1. Land Use Planning

Council Submission Recommendation (November 2021)	Response to Submissions Report (April 2022)	Council Comments (June 2022)	Response to Request for Further Information (December 2022)	Council Comments (February 2023)	Response

3 SHADOW ANALYSIS - 3PM
SCALE: 1:1000

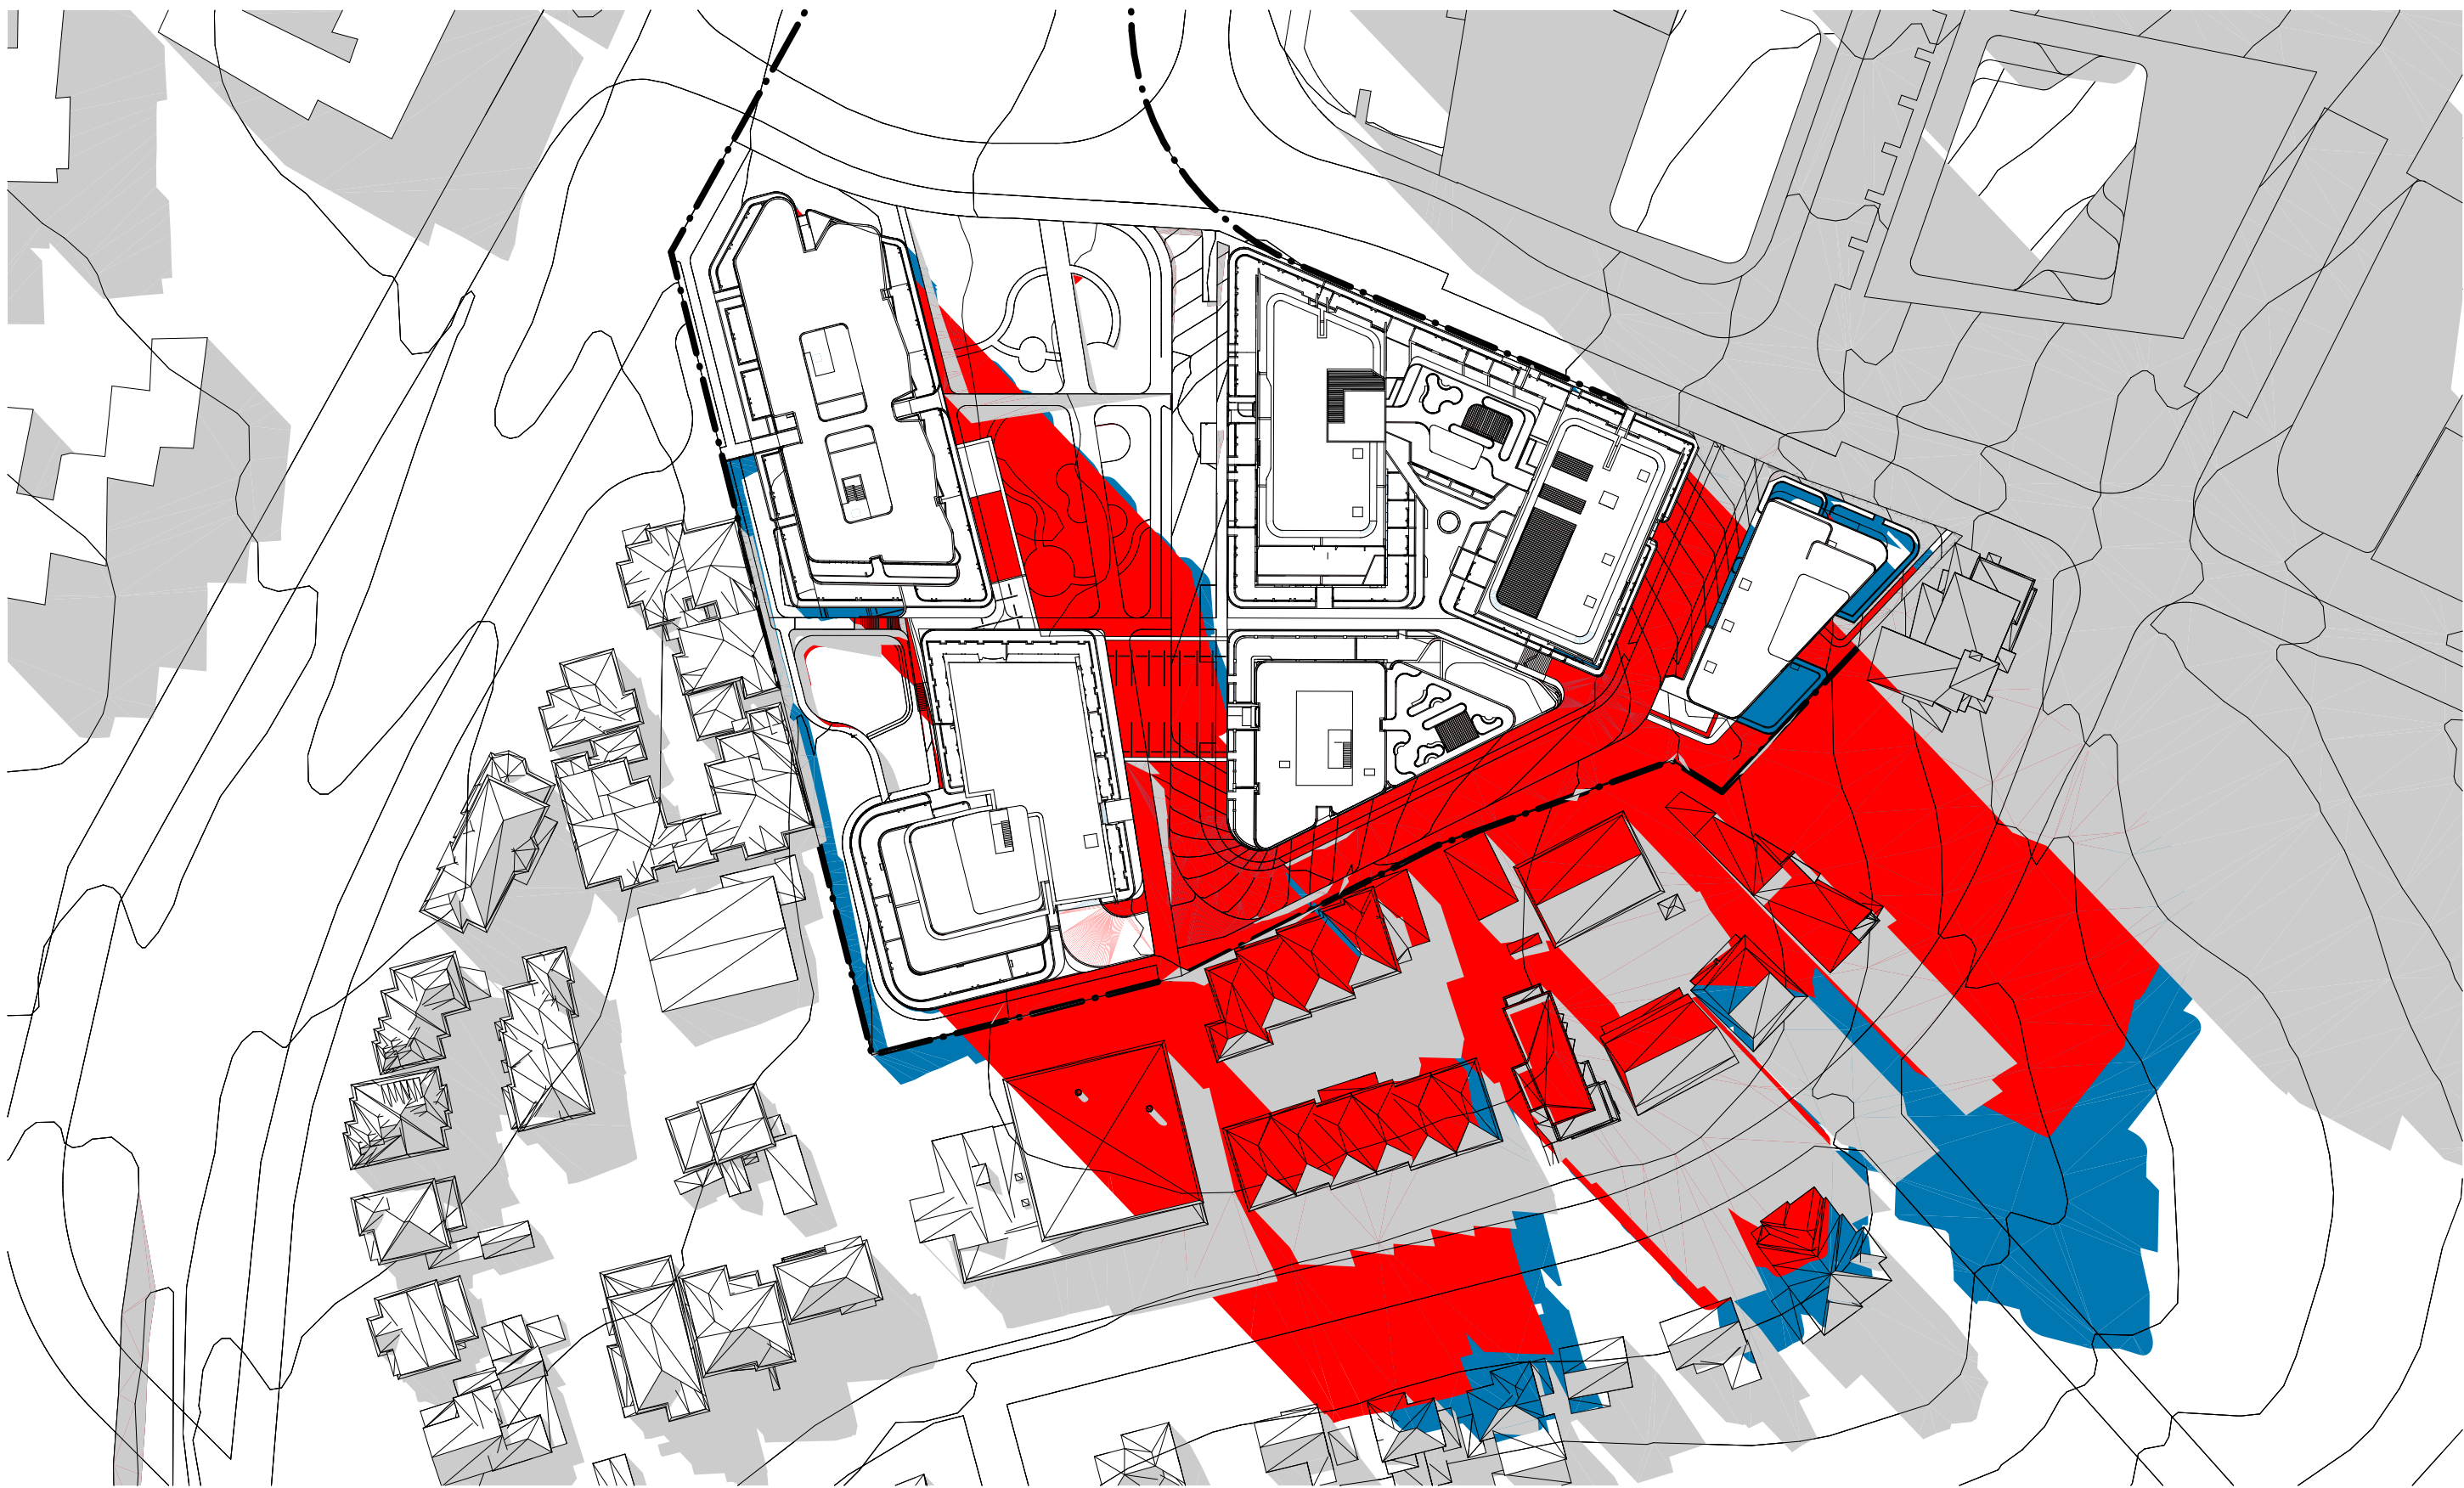
<i>Solar Analysis:</i> Solar analysis centres on the number of hours of sun access to spaces but does not consider the time of day these spaces may receive additional	Solar access shadow diagrams have been prepared by Bates Smart and are included in the Design Concept Plan Report. Shadow diagrams have been prepared for hourly intervals from 9am	<p>Solar analysis must clarify the difference between a 'Proposed Envelope' and an 'Indicative Design Scheme.'</p> <ul style="list-style-type: none"> • The following buildings must comply 	Refer to ADG Summary for Concept Works prepared by Bates Smart (Appendix C of RFI Letter) which confirms 70% of apartments in N6.1 and 72.1% of

overshadowing from the proposed buildings. Hourly solar diagrams should be provided for each open space to assess when overshadowing may be happening (i.e., if there is additional overshadowing during the lunch period this is a concern).	to 3pm for 21st June, representing the greatest overshadowing impact through the year. The shadow diagrams compare the shadow cast by existing development at the site, shadow cast by a building height compliant with the PLEP 2011, shadow cast by the proposed Concept Approval building envelopes, and shadow cast by the reference scheme.	with the minimum ADG requirements for solar access (75% of apartments) – N6.1 and S5. • The following buildings must comply with the maximum ADG requirement for no sun (7% of apartments) – N7.2, N9.1a, N9.1b, S2, S7, S8. Reconsider building C6.1c which does not result in enough apartments receiving the minimum solar access and exceeds the maximum number of apartments that can receive no sun.	apartments in S5 achieve two or more hours of direct solar access to primary living areas and private open spaces between 9am to 3pm in mid-winter in accordance with Objective 4A of the ADG. Refer to Section 2.3 of the RFI
